UNSW

WALLACE WURTH REDEVELOPMENT

ACCESS REVIEW

10th June 2010

GFA GROUND FLOOR: 2,753 m² 1 Ground Floor 1:400

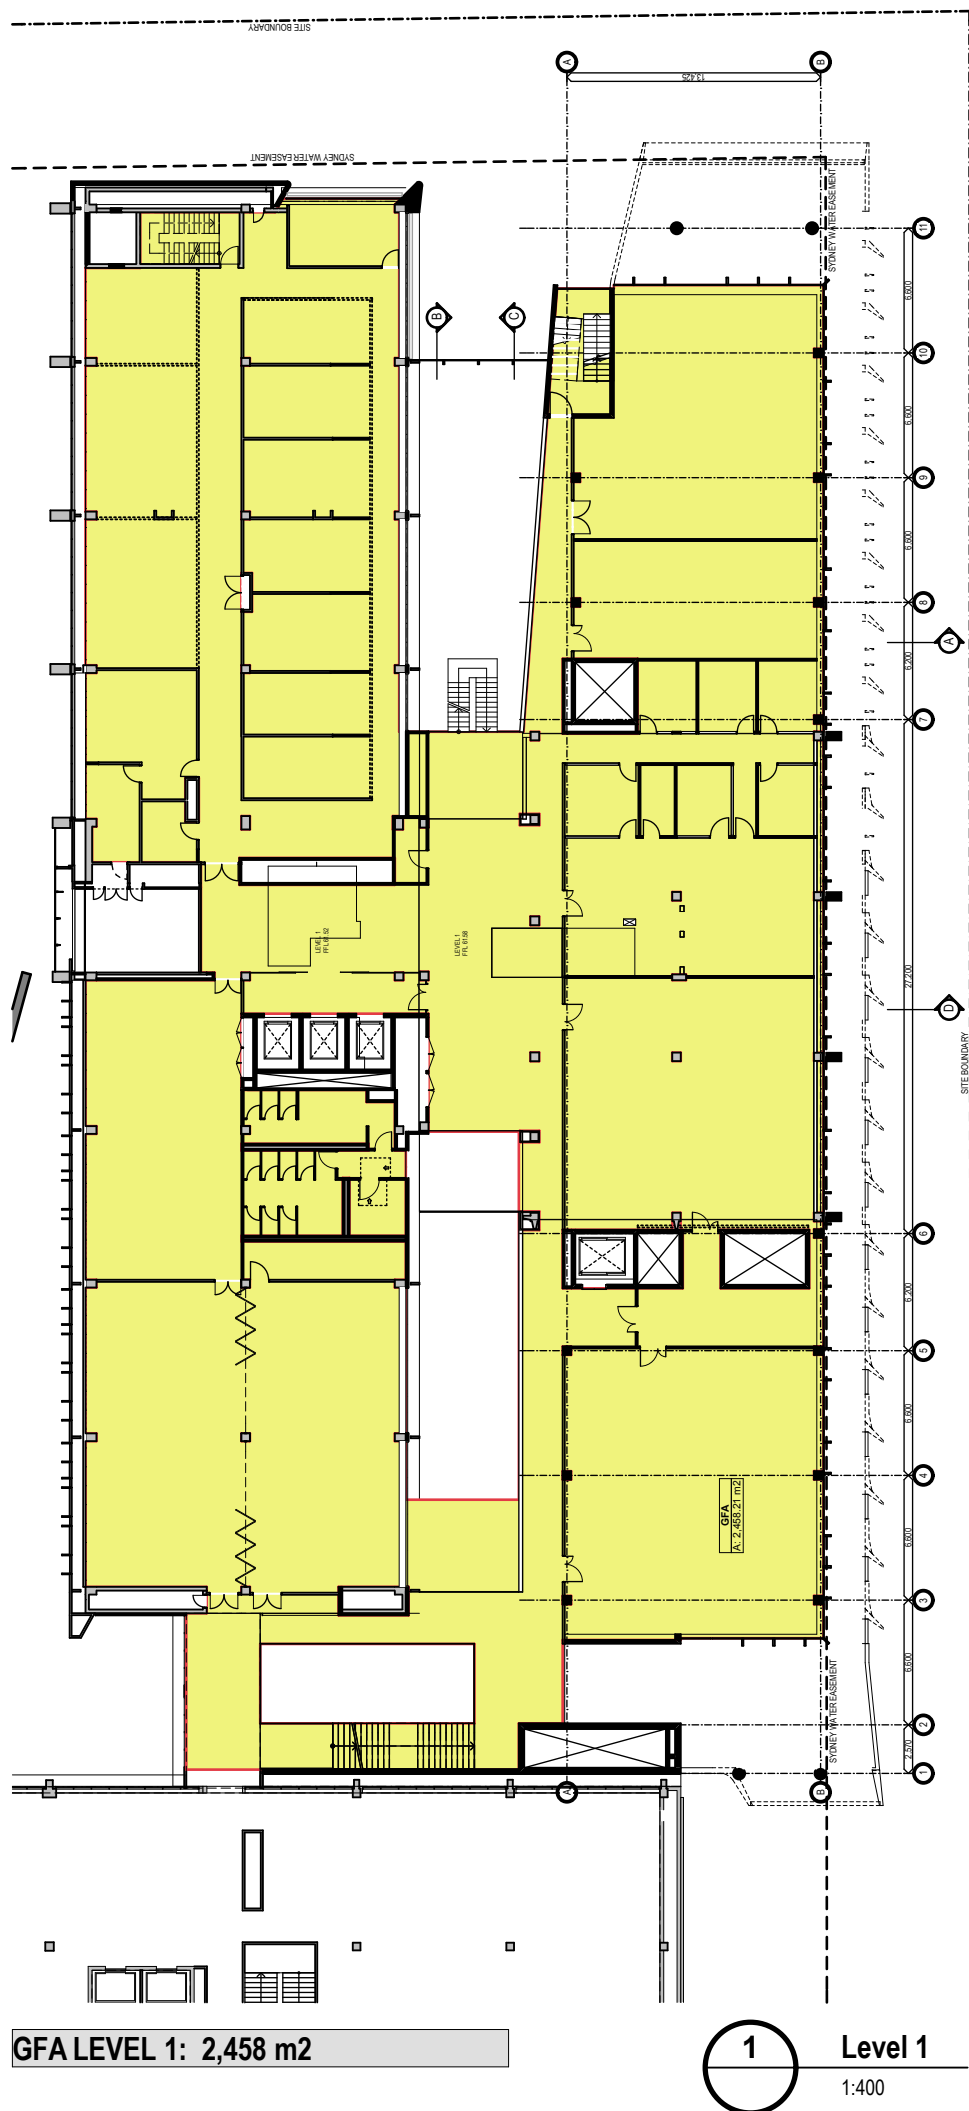
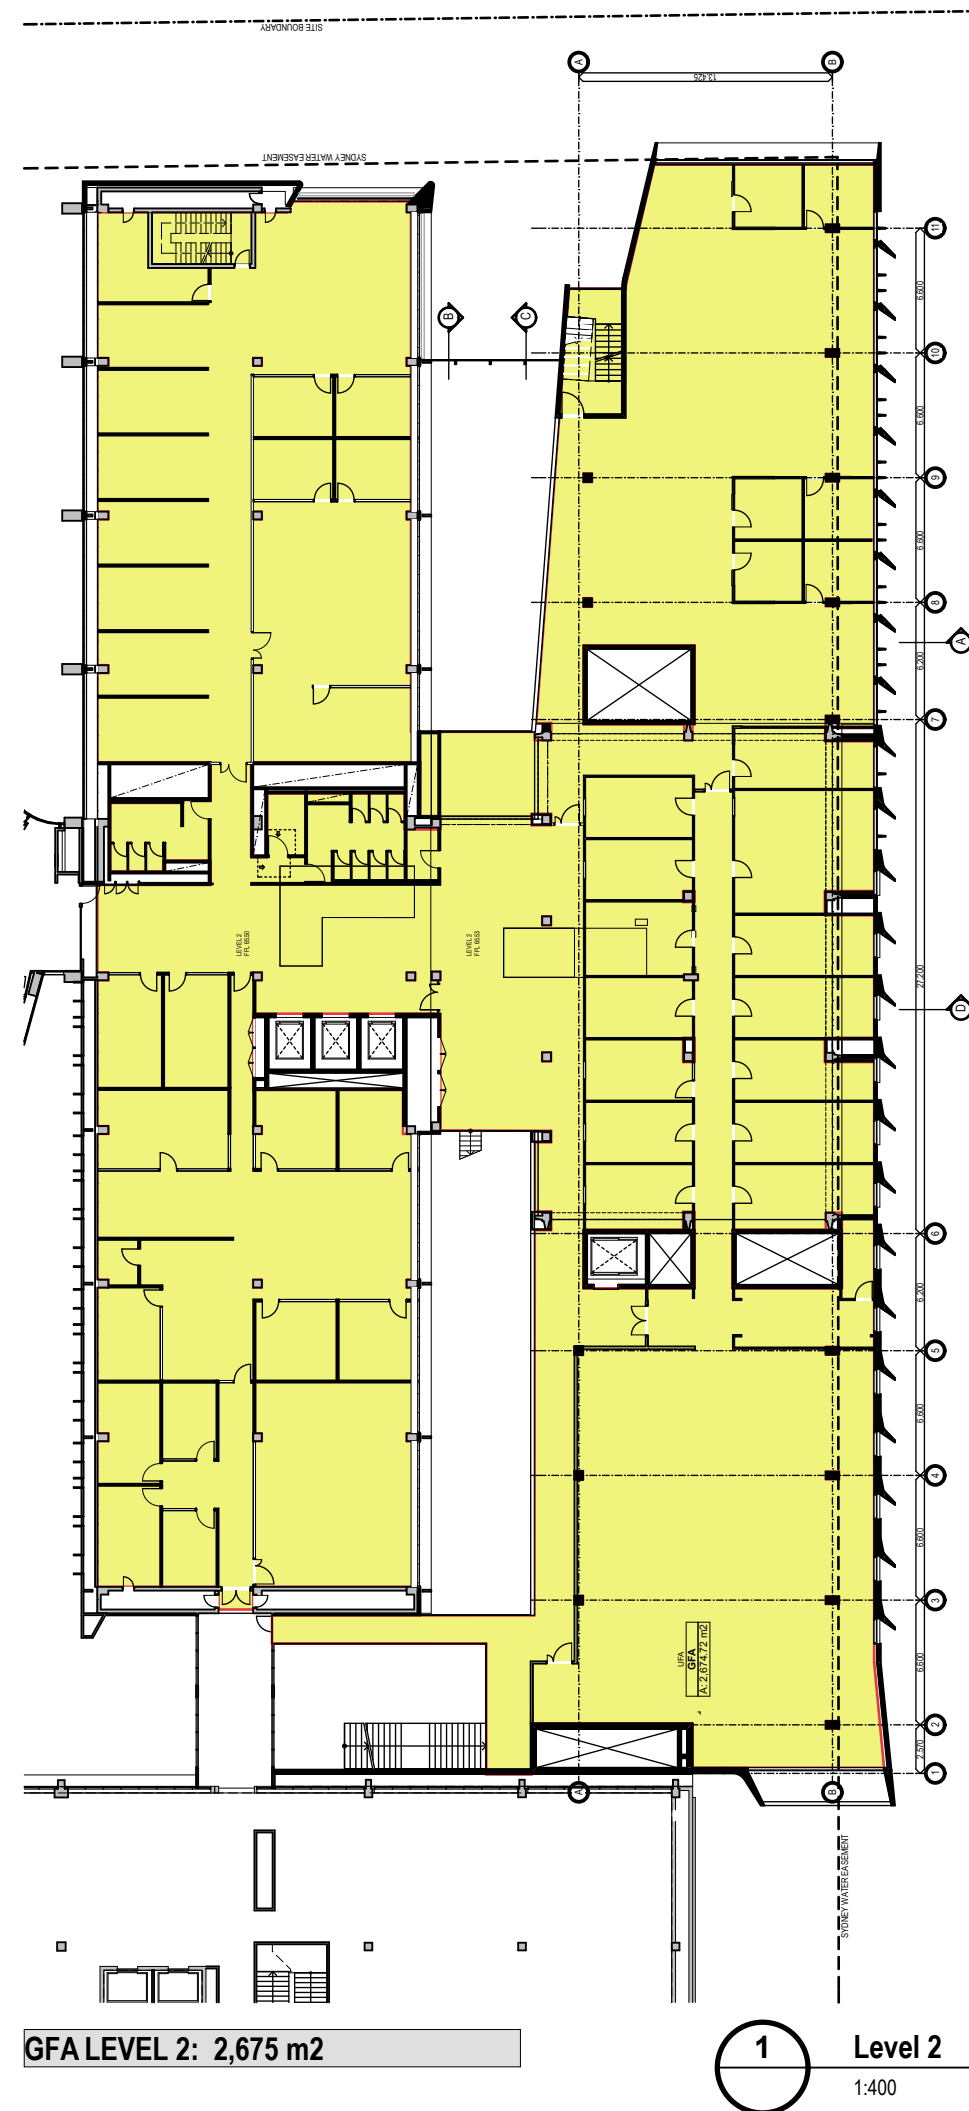
- (i) The ramp will need handrails on both sides in accordance with AS1428.1 with 1200mm width between handrails. The ramp should have mid landings of 1500mm long.

The emergency egress stairs are evenly spread throughout the building. The emergency fire stair doors leading out onto the ground floor have 800mm clear width.

There is dual egress doors located on the southern end of the building. The egress doors have 800mm clear widths.

- (i) Consideration is needed for all fire stair doors to have 850mm clear widths (920mm door leaf). This will allow some level of fire safety protection for a person in a wheelchair (best practice).
- (ii) If applicable emergency alarm systems should include audible and visual warnings indicators in assisting people with sensory disabilities.

- (i) Certain doors within office and science areas need at least 1200mm clearance in front of doors.
- (ii) Corridor door on level 2 leading to Meso Admin needs at least 470mm latch side clearance
